Subject: Application 3/2018/0220 & 0221 - Thornbers, Waddington
Attachments: THORNBERS RESPONSE.pdf; internal_wall_insulation_application_guide.pdf; site_mix_lime_screed_amp_wearing_surface_for_use_with_technopor.pdf; Ventrolla - Brochure - Bespoke New Timber Windows.pdf; Ventrolla - Brochure - Sash Window Renovation.pdf; PGB-2931_Proposed_20.07.18.pdf

Application 3/2018/0220 & 0221

Thornbers, Waddington – listed Grade II

Proposed Floor Plans
 DATE 14.03.18

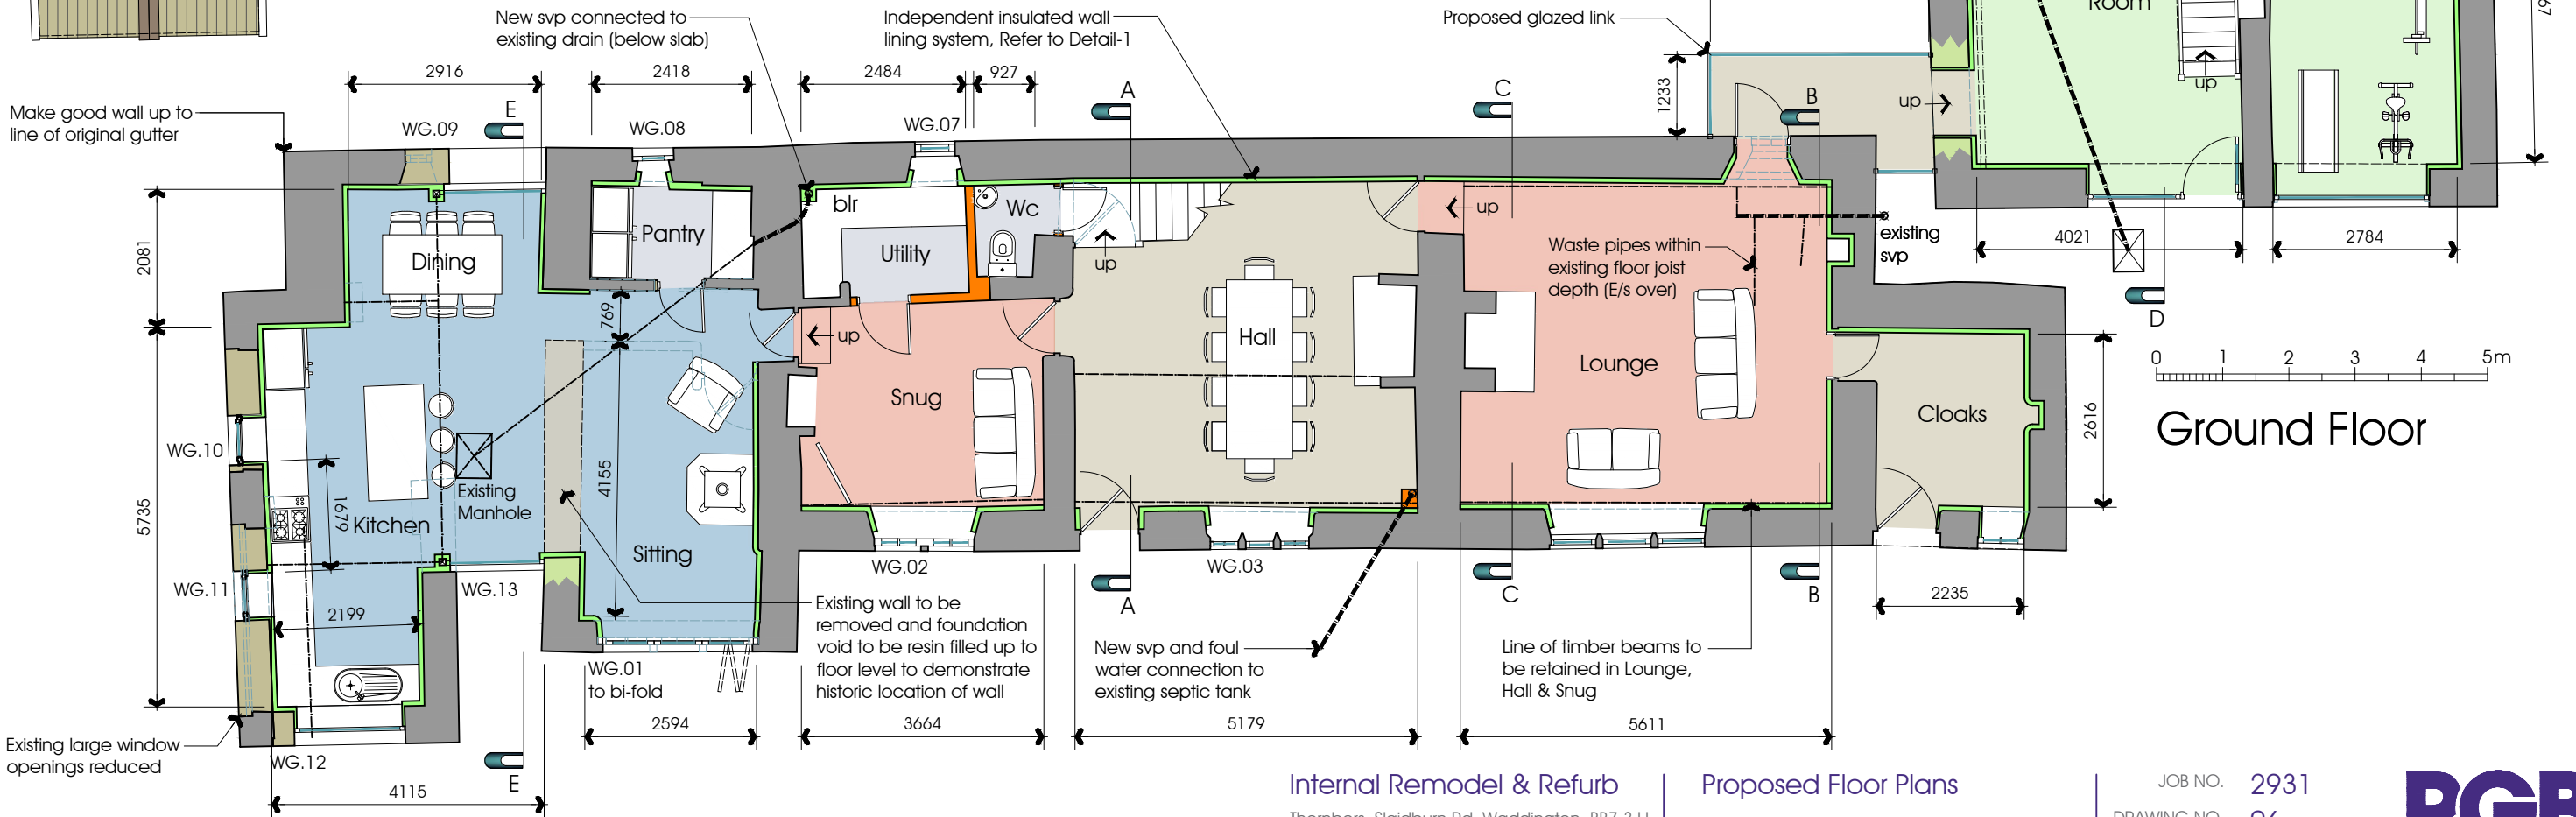
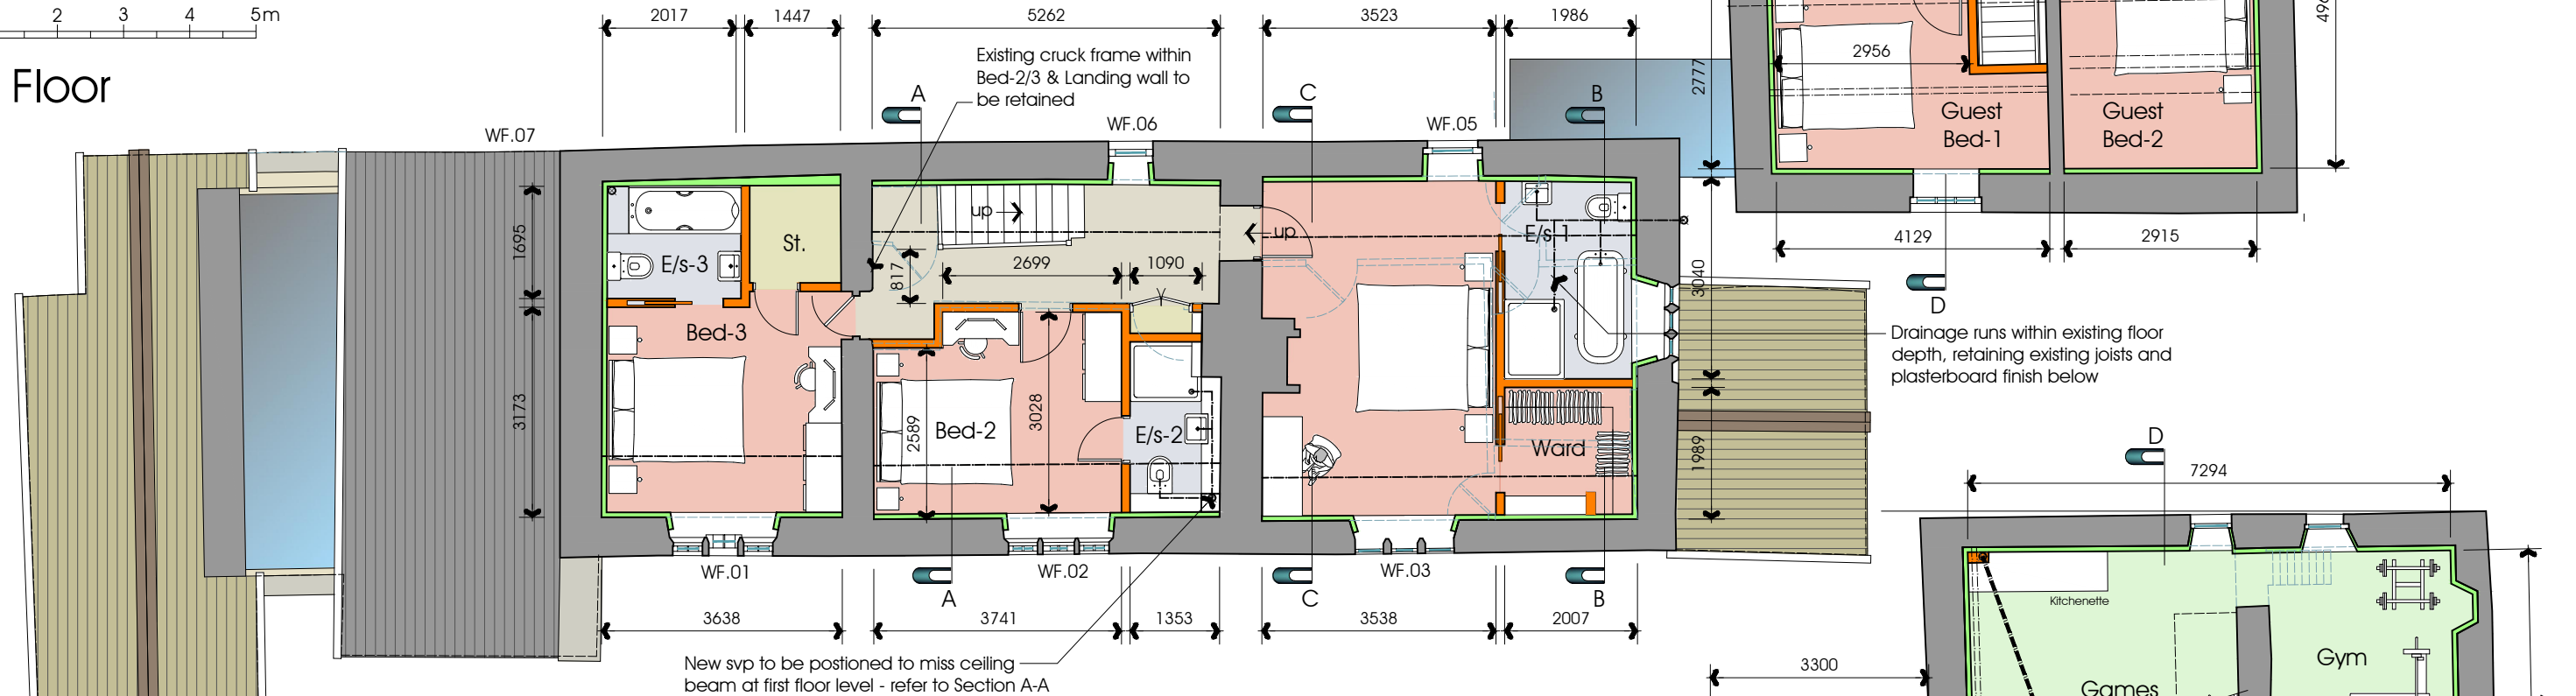
proposed in C17 fabric (close to the east gable and its window). Can a link be created which avoids loss to fabric of High Significance?

Proposed Bed 3 would appear to be the only First Floor room which has retained its original proportions (C17 or earlier). As discussed on site, I would therefore welcome further consideration to retaining this important element of planform in the proposed works.

We note your appeal decision attachments and have not been certain of the implication of this, however in response; we have now adjusted the location of the frame-less glass link to reduce its surface area significantly and; so we do not affect the fabric of the older parts of the property. The glass link being very short does not need to be artificially lit and will also use none reflective glass as will the glass to the kitchen link. Please be more specific if the appeal documents implied something else.

We acknowledge your concern with regard to the subdivision of bedroom 3 and propose a 1750 high privacy screen so that the original shape of the room is retained

South (front) elevation 0 1 2 3 4 5m

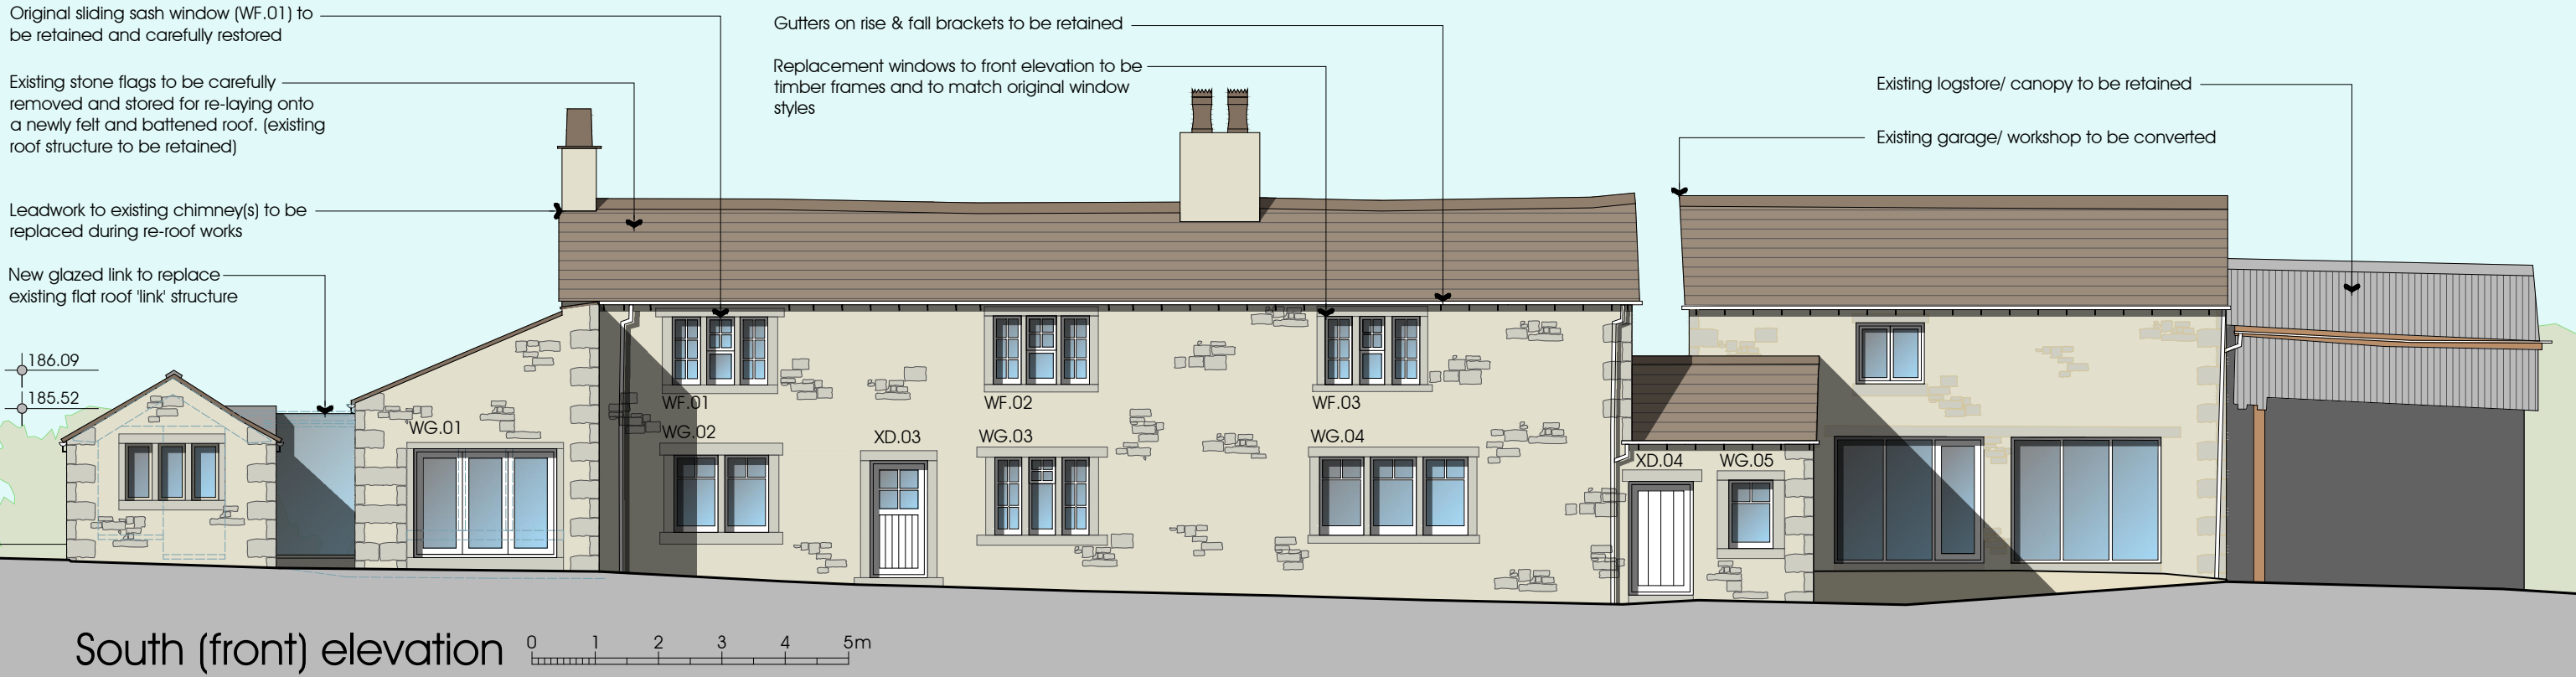
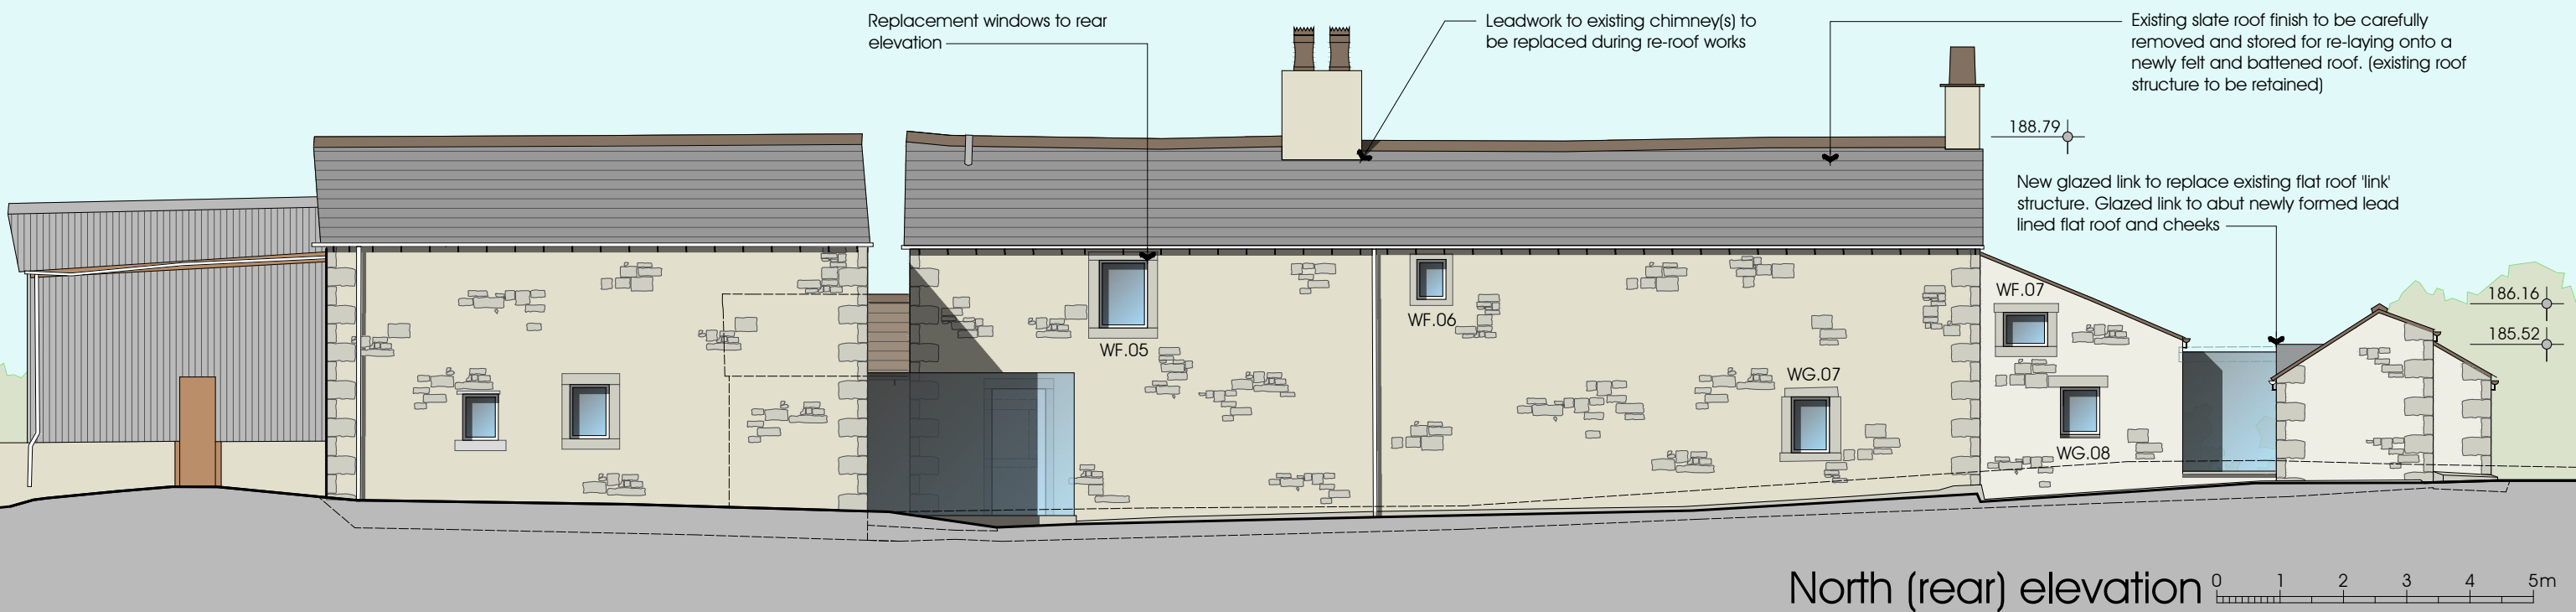
I welcome proposals discussed on site to minimise the impact of new fenestration in the former stables, cartshed/garage and garden room (extent of glazing and number of lights to the former ancillary building windows which competes with the higher status main range). For information, I attach a link to Historic England advice and recent appeals.

Mindful of the loss of character to the front elevation of the former stables resulting from 3/1993/0641, has consideration been made to possible enhancement from restoration of the tall and narrow doorways? (stables are discussed at page 66 of <https://historicengland.org.uk/images-books/publications/historic-farmsteads-preliminary-character-statement-north-west/>).

I would be grateful for the submission of further information concerning the significance of existing windows and how this has informed proposed replacements. I recall from pre-application discussions that there was speculation as to whether window WF.01 was original to this house? Why does proposed window WG.03 not conform to that shown in Figure 6 of the Heritage Statement? Are windows WG.02 and WG.04 based upon historic windows or is there enough evidence to suggest replacements follow the style of WF.01? The 8-pane side windows to WG.03 (Figure 6) appear in proportion and in line with the central light – is there enough evidence to suggest the 6-pane 1970s side windows throughout the elevation could be replaced with 8-pane?

I am concerned that the proposed window beads referred to at page 4 of the Planning Statement will not safeguard the character of prominent front elevation windows (see Historic England advice in respect to the replacement of windows <https://www.historicengland.org.uk/images-books/publications/traditional-windows-care-repair-upgrading/>).

We have adapted the windows in line with our telephone discussion to use sliding sashes without glazing bars and 8 panel fixed lights either side. We have however kept and propose to refurbish the existing sliding sash within WF01 because of its age and; whilst this appears to be a window from another building just fitted into this gap without too much care, we still feel it is an important story to this listed building - if you disagree and would prefer to match the proposed sliding sashes then please let us know.

We have reintroduced the original stable doors into the garage which helps strengthen the dividing wall and therefore allows us to provide a door between the two spaces in a more sensible location. If the fold back timber doors should look more like original stable doors then please advise. We have also tried to create a more agricultural feel with similar bi-folding screen to the original cart shed opening.
